**Consultation Response from KC,
Highways Development Management****2026/91359 Moss Edge Farm, Moss Edge Road, Holmbridge, Holmfirth, HD9 2SD****Erection of agricultural building and access track****Date Responded: 22 June 2026****Responding Officer: Sheila Henley****Responding Ref: K3-25/1****Recommendation: No objection.**

Plan reference: 352-25-PL01_A - Proposed Site Layout

Drawing Title PROPOSED SITE LAYOUT

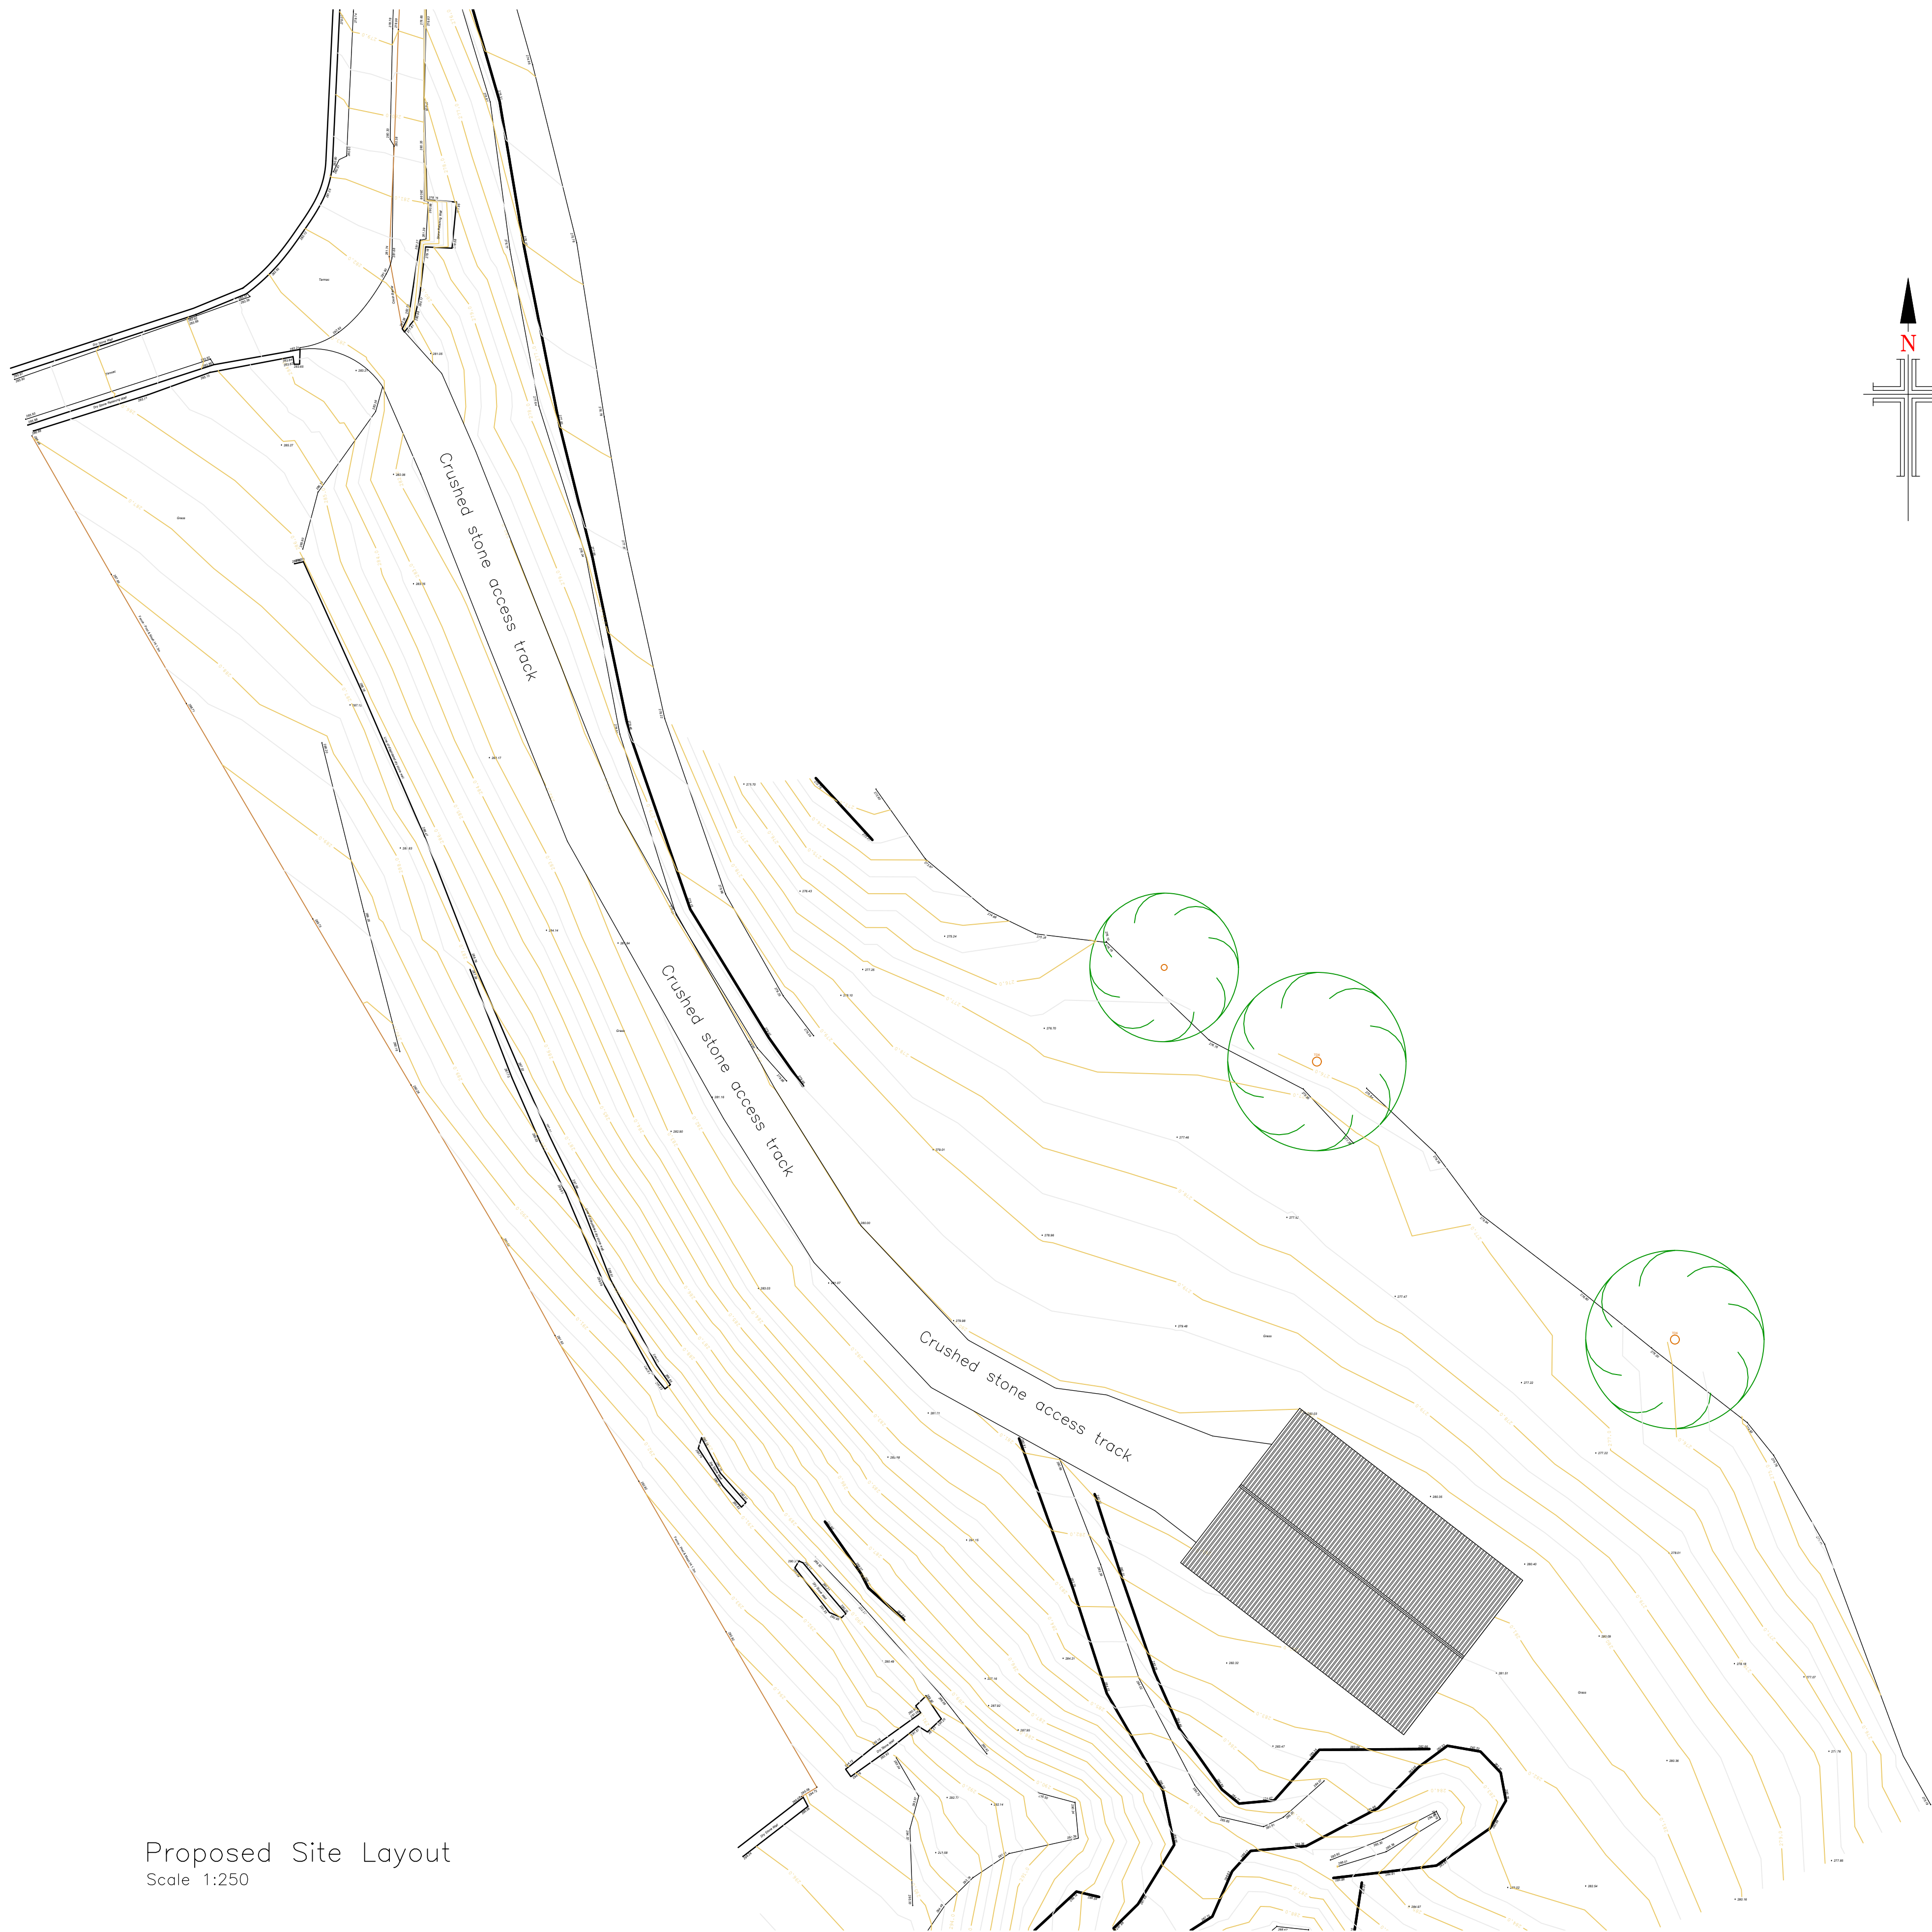
The proposed access track would be formed off the existing unadopted Moss Edge Road to lead to a new agricultural building.

The main access from the public road Hollin Brigg Lane / Woodhouse Lane is retained as is that to the main farm buildings and other properties along Moss Edge Road.

The proposed layout of the track access junction is adequate with sight lines maximised from being on the outside of a bend. The intended track would be of a suitable width with an appropriate surface material for the intended use by agricultural vehicles in the main. The surface may need regular top up since crushed stone is often less durable than other surface materials, especially when used by heavier vehicles. Its gradient should be between 8 and 10%.

At the location of the proposed barn there would be space for parking, turning, and shepherding.

Drawing Title
PROPOSED FLOOR PLAN
& ELEVATIONS

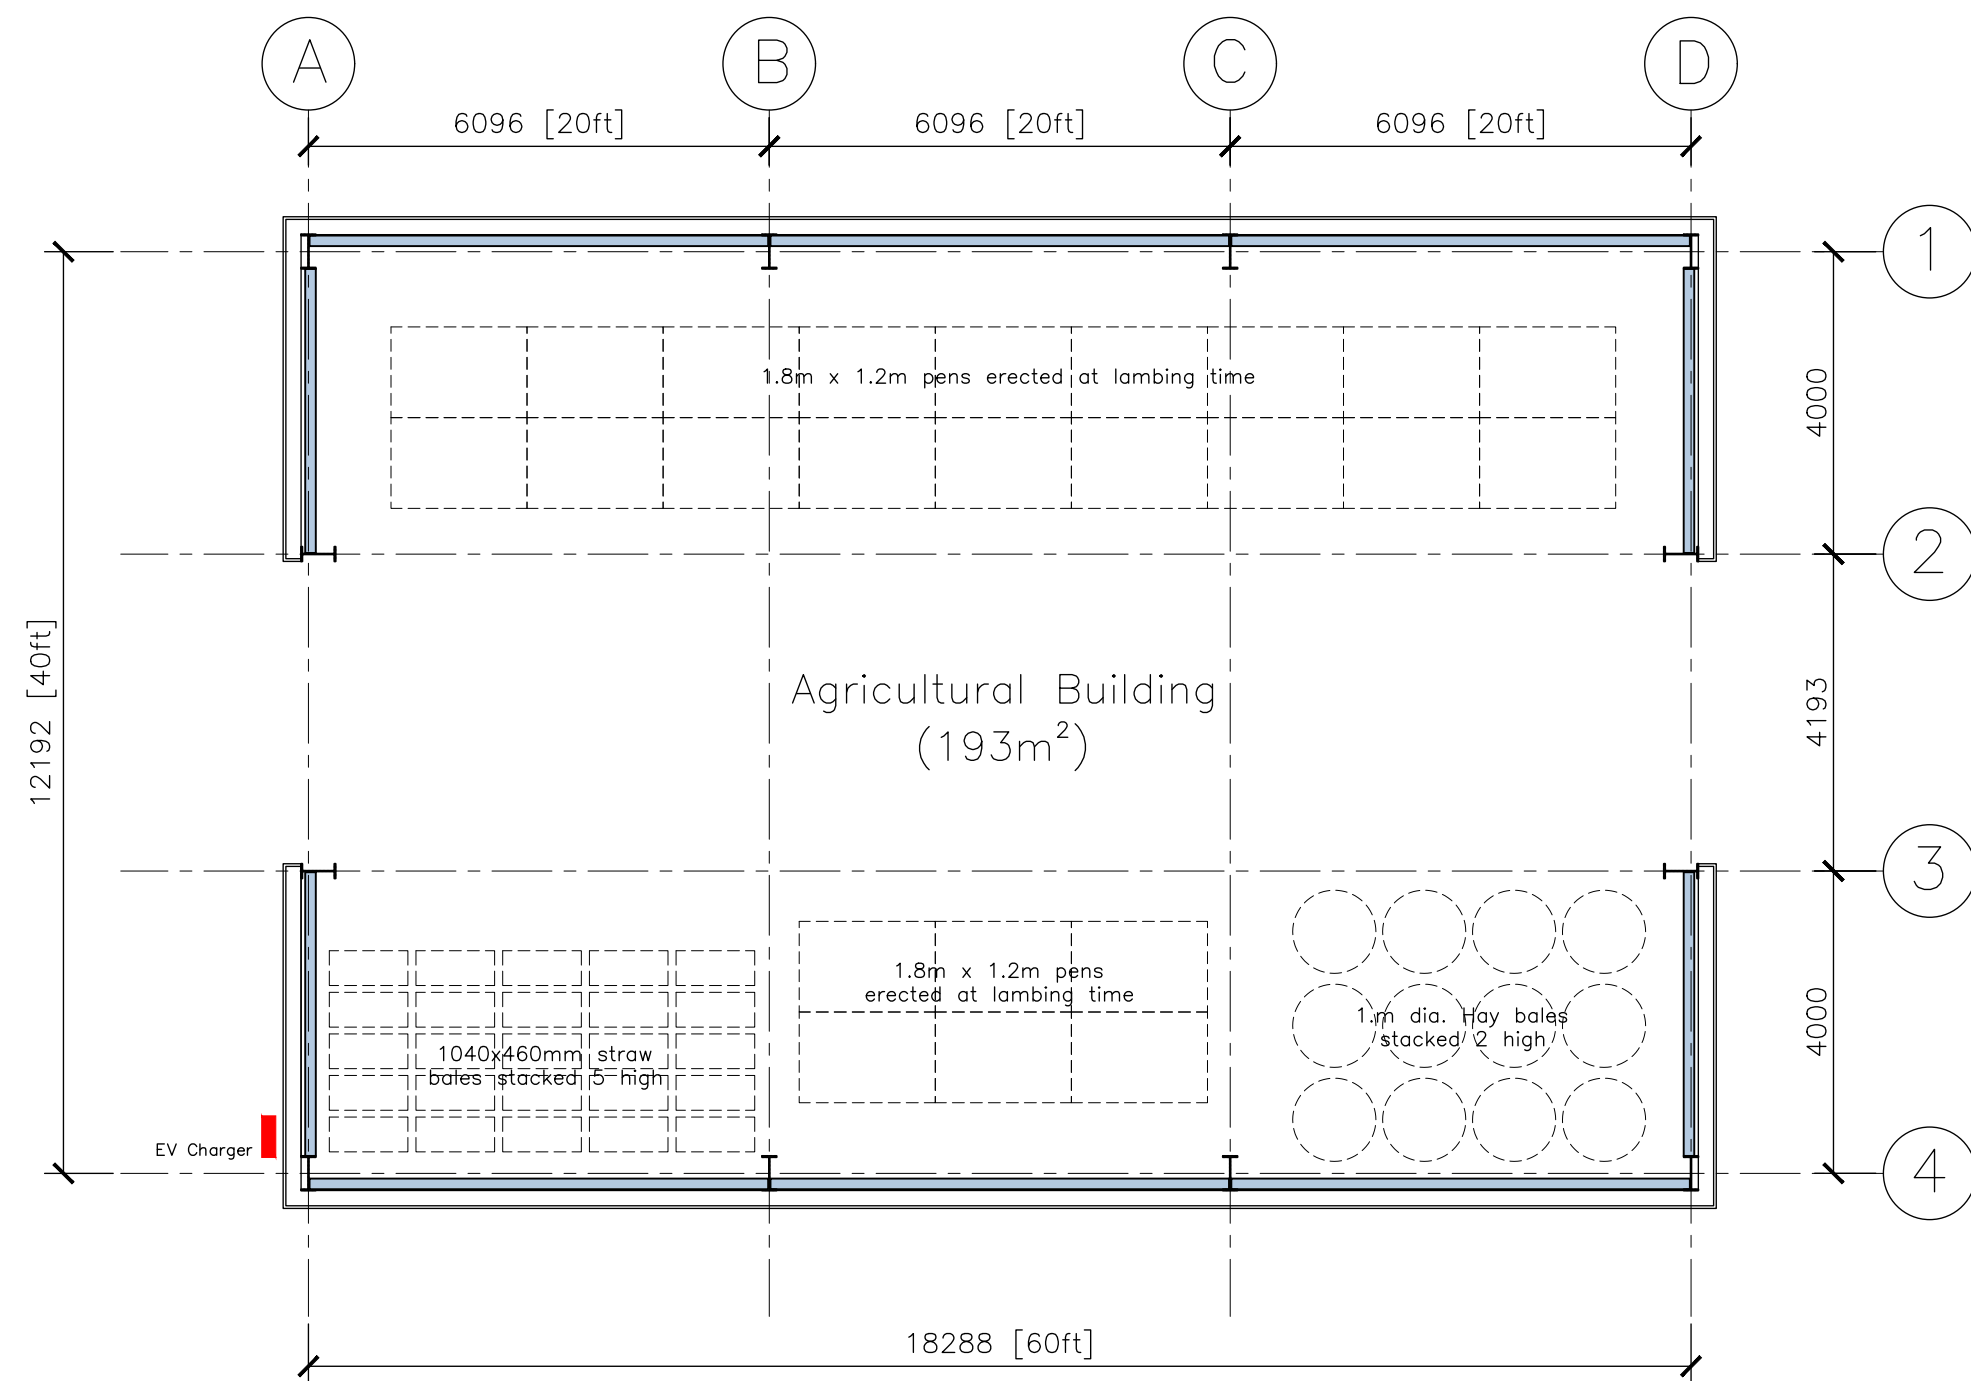
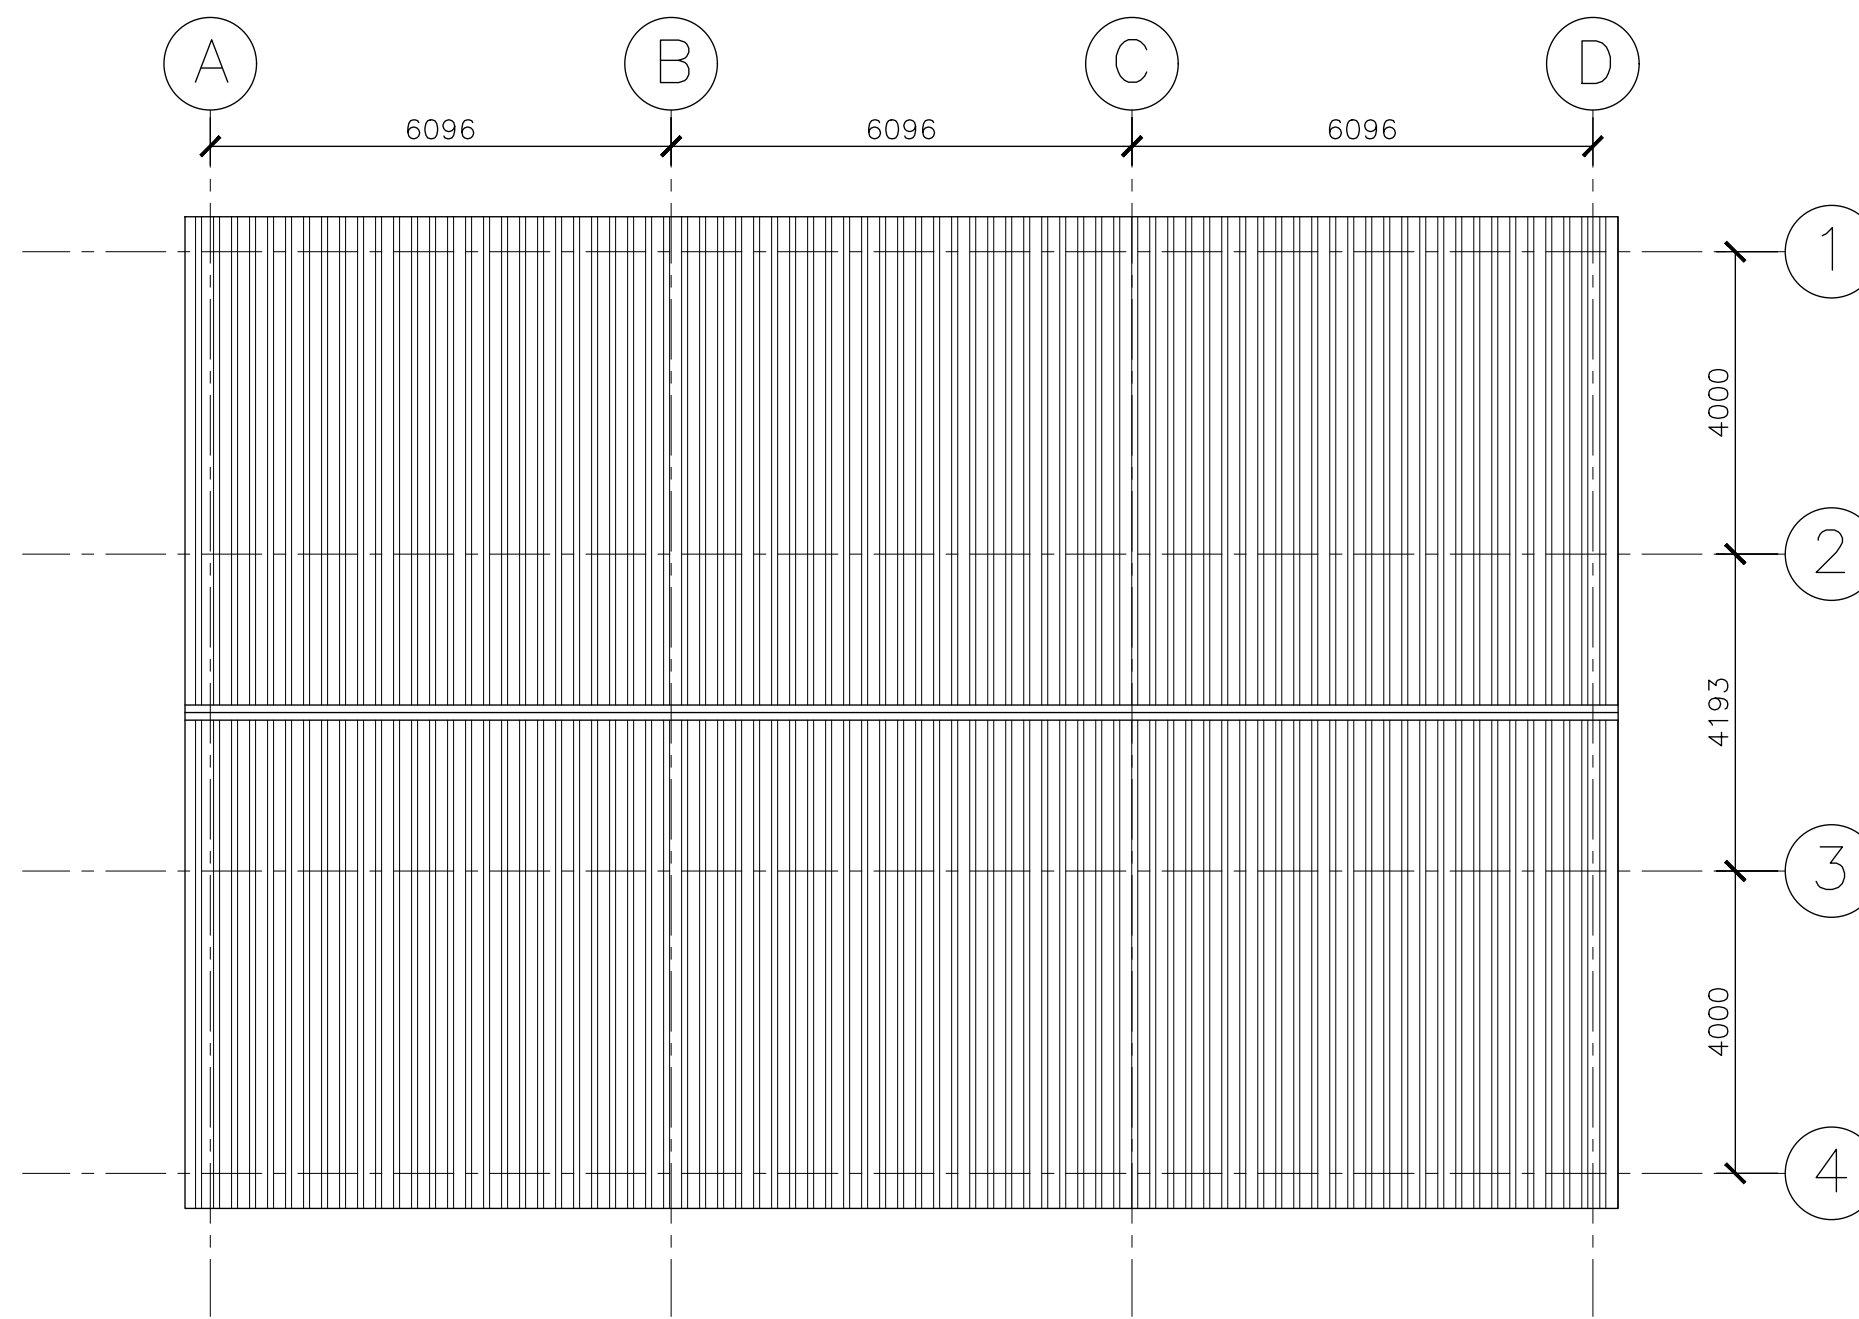
An electric vehicle charging point should be considered to support policies LP20 to encourage sustainable travel and low emissions.
